PLANNING CONSULTATION RESPONSE

Application No	2026/0402
Proposal	Conversion of existing attached garage to ensuite bedroom and first floor side extension above
Address	27 Chapel Street, Birdwell, Barnsley, S70 5UW
Date of Consultation Reply	27 th August 2026
Consultee	Highways DC

[2nd response]

Site plan

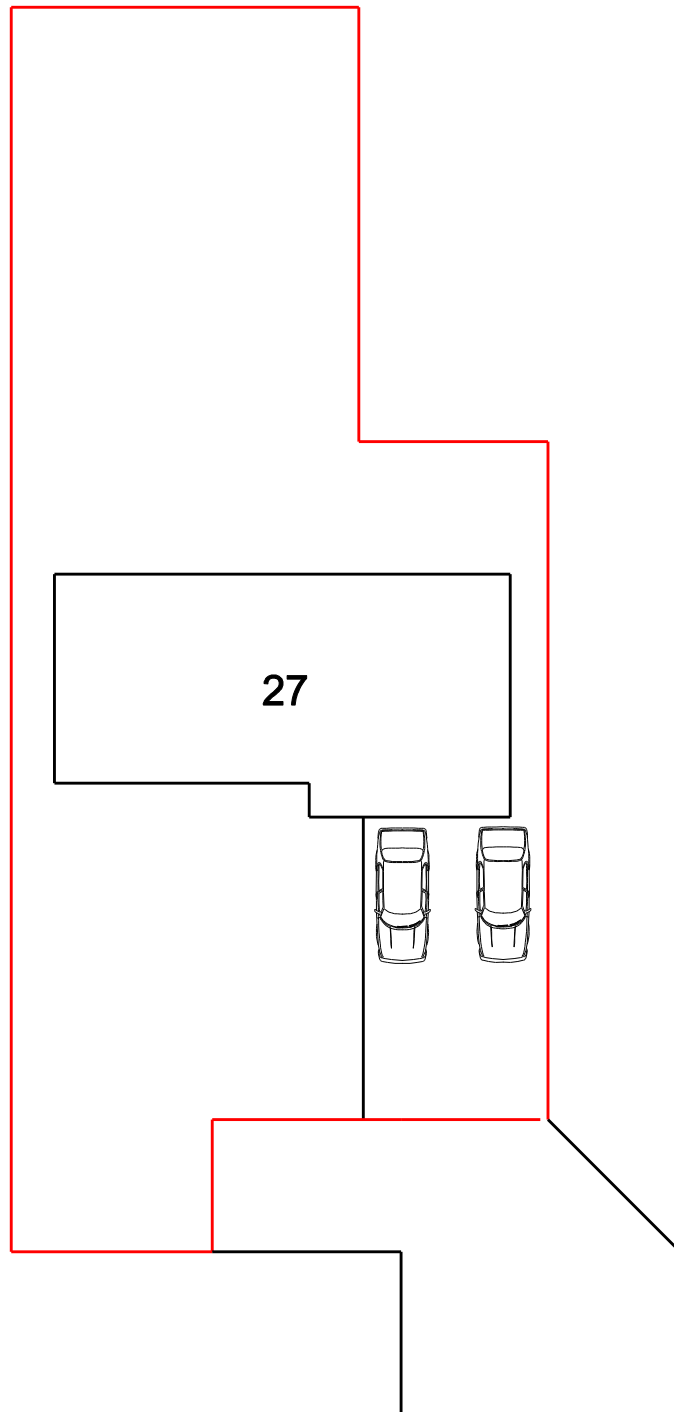
With reference to the amended Site Plan Rev. 2, the proposals now include an extended turning area which will allow vehicles parked on either side of the widened driveway to carry out a turning manoeuvre. A bin store is to be provided at the end of the extended turning area.

The parking and manoeuvring facilities, indicated on the submitted plan, shall be surfaced in a solid bound material (i.e. not loose chippings) and made available for the parking and manoeuvring of motor vehicles prior to the development being brought into use, and shall be retained for said purposes at all times.
